16 August 2016

Re: Letter of Objection to State Significant Development 7421 for the Proposed Expansion of an Existing Waste Management Facility at 20 Hearne Street, Mortdale.

I refer to **SSD 7421** for State Significant Development (“SSD”) application to increase the capacity of the existing Waste Management Facility at No 20 Hearne Street Mortdale (“the subject site”).

Figure 1: Site Plan

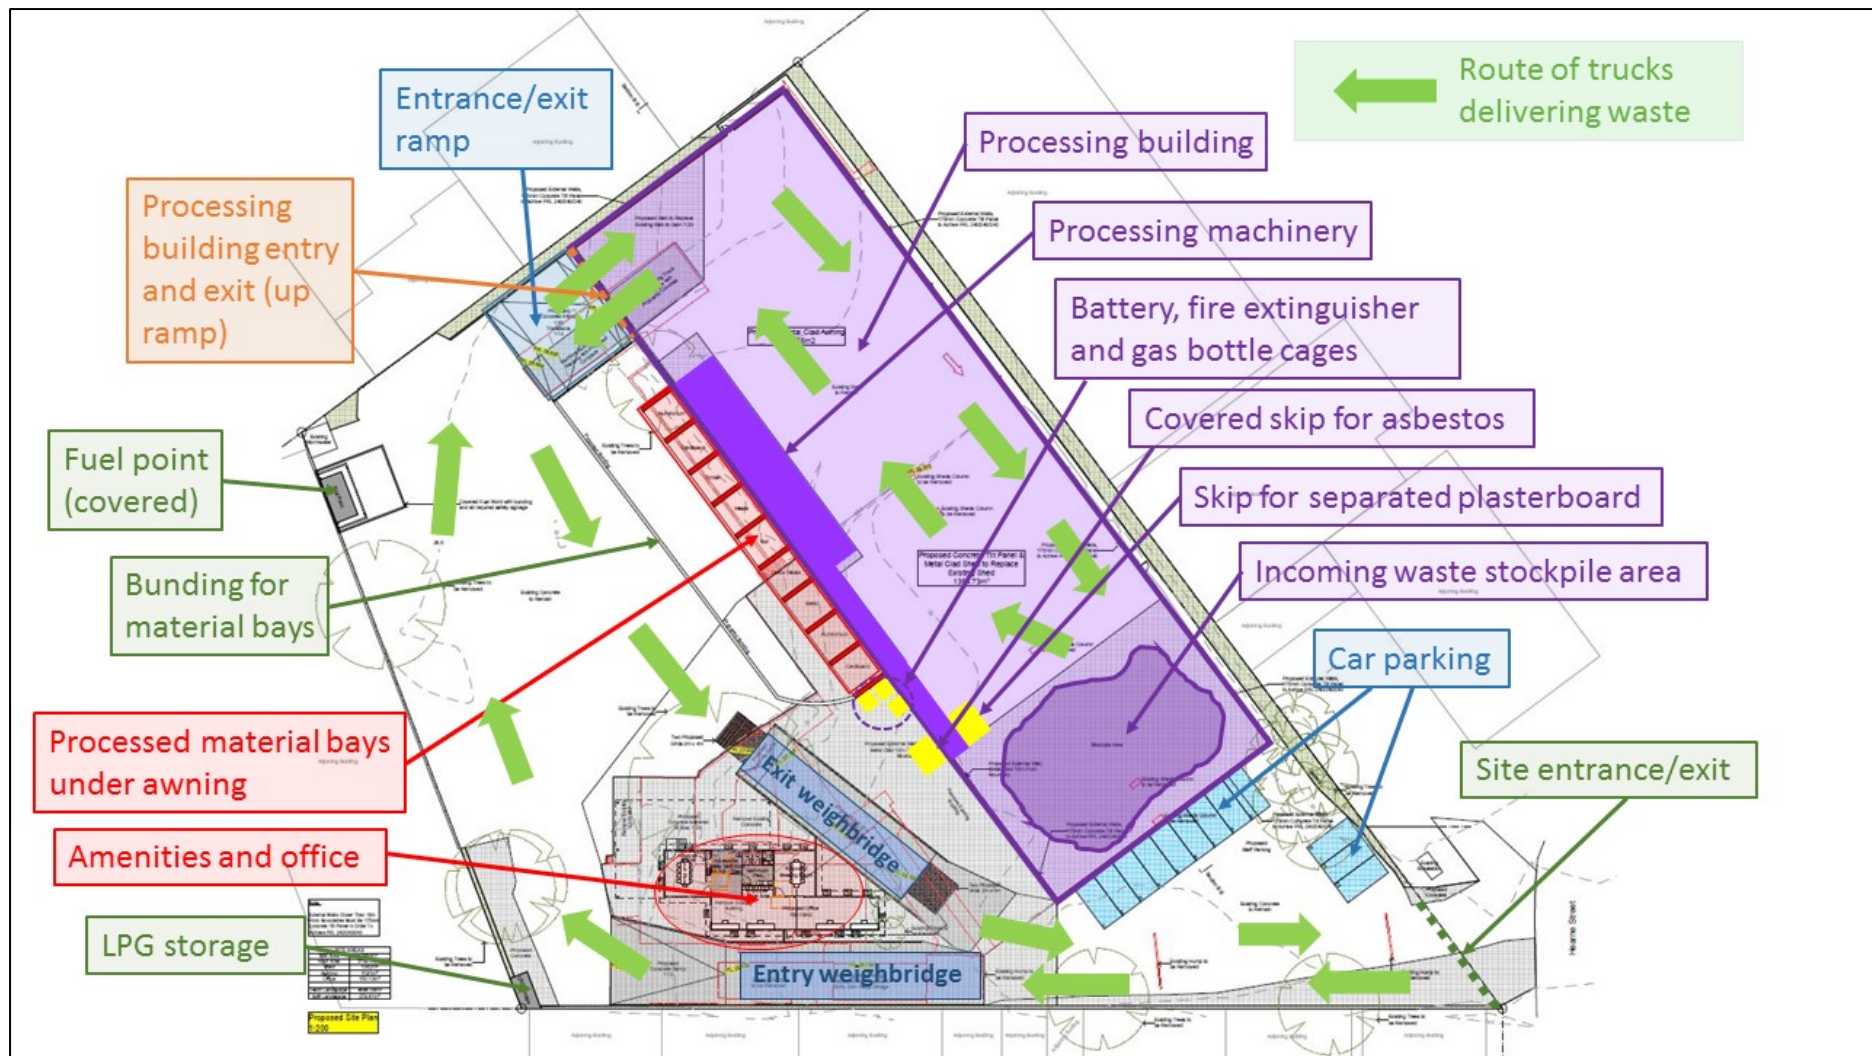
The operation of the premises as outlined above is concerning in that there will be bins full of waste being stored outside and while it is proposed to cover these bins, in practice this is unlikely to be undertaken. Such a condition would require significant compliance action which is unlikely to be undertaken.

The placement of bins full of waste to be stored outside until “accepted for processing” results in full bins sitting outside for an unlimited time period which has significant potential to result in dust and other air pollution affecting adjoining and nearby properties. This is illustrated in **Figure 3**.

Figure 5 | Location of Stacking Spaces

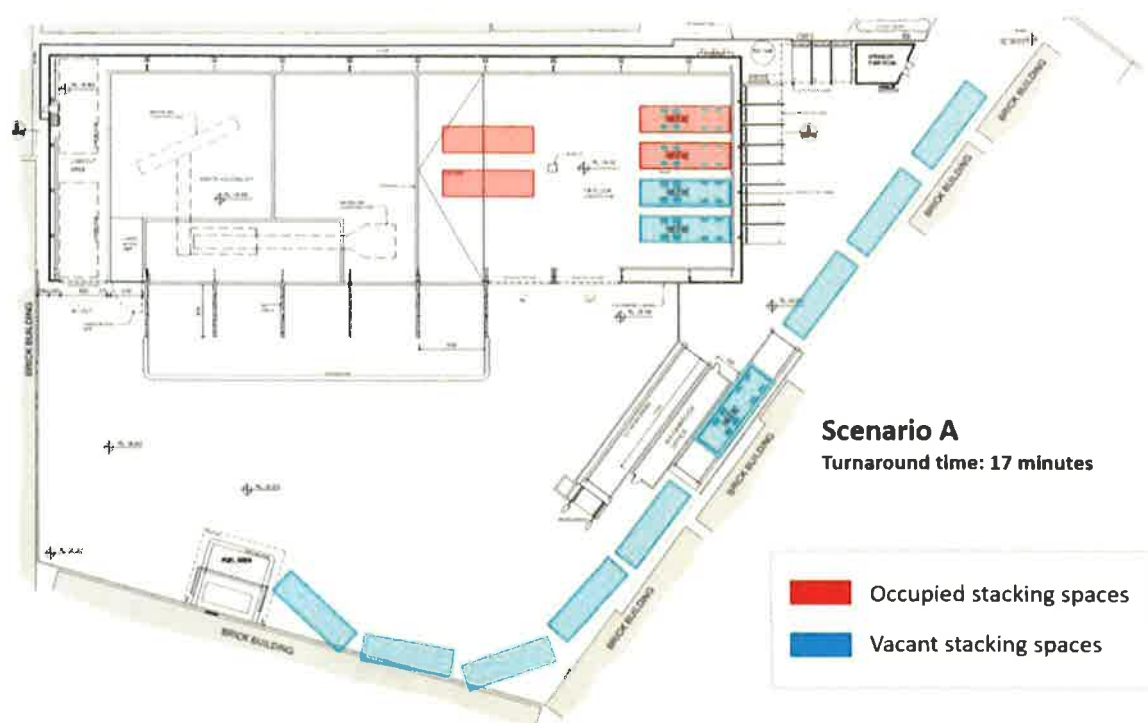
Therefore, it is doubtful that two trucks can pass at the driveway entry to the site, which would lead to queuing into Hearne Street while the outbound truck departs the site. This is totally unacceptable as Hearne Street needs to be kept clear at all times for other traffic to pass and other businesses in the street to operate effectively. This is of major concern to businesses in Hearne Street and renders the proposal unacceptable.

This again is likely to result in trucks queuing in Hearne Street waiting to access the site while outbound trucks depart the site. This is totally unacceptable and warrants refusal of the application.
